Application No: EP/22/21/HH
Site Address: 15 The Plantation East Preston BN16 1LD
Description of works: Erection of rear extension and loft conversion with rear dormers and side gables

Thank you for your internet representation made on 7th May 2021 which has been recorded as an objection with the comments as follows:

Plans & Elevations As Proposed

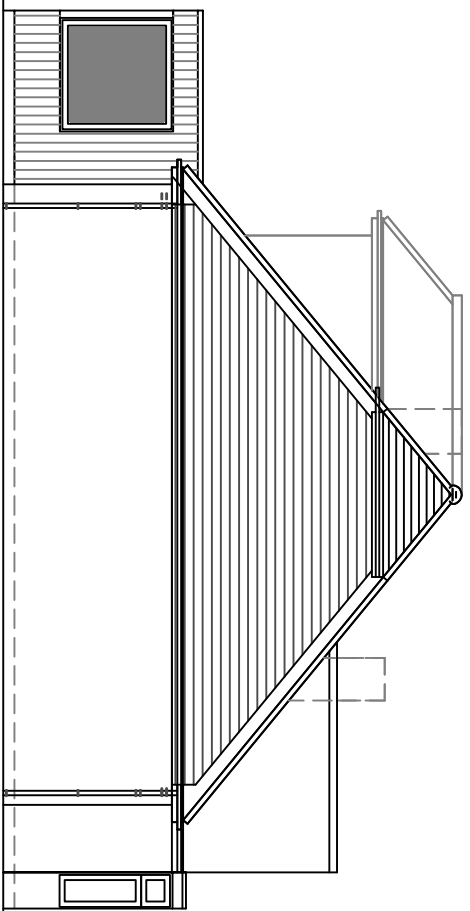
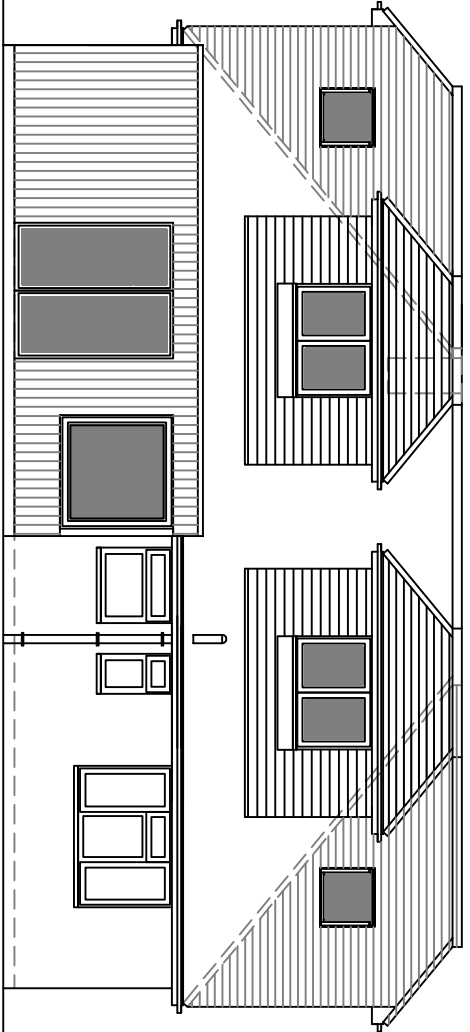
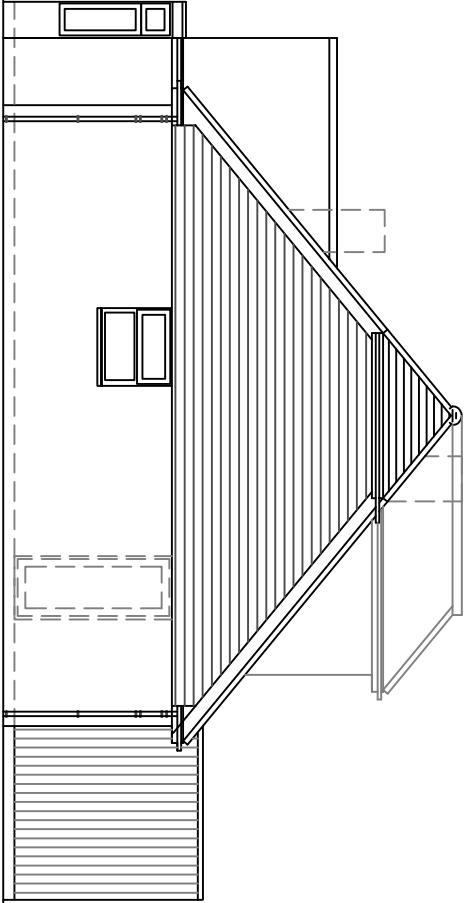
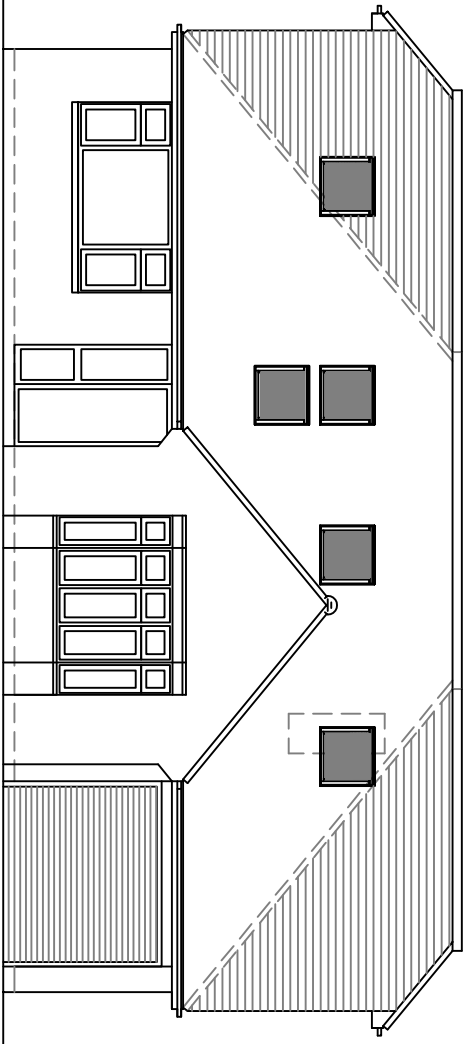
This application would transform the existing bungalow into a barn-like chalet. The roof would be rebuilt with a long straight ridge, to create space for three bedrooms, with dormers along most of the rear of the roof to provide light. The result would be a chalet bungalow in which the roof would appear to dominate the building, and where the roof very obviously was not a part of the original design of the building. This rather ungainly building would be out of character with the original bungalows in the road, and would add a discordant feature to the street scene.

This proposal contravenes Policy 3 of the East Preston Neighbourhood Plan, which requires that where rooms are created in a roof, the basic form of the roof is not altered. It also contravenes Policy 1 of the Neighbourhood Plan, because the altered building would not reflect the architectural character of the surrounding buildings; and Policies D DM1 and DM4 of the Arun Local Plan, because the revised building would not reflect the character of the area.
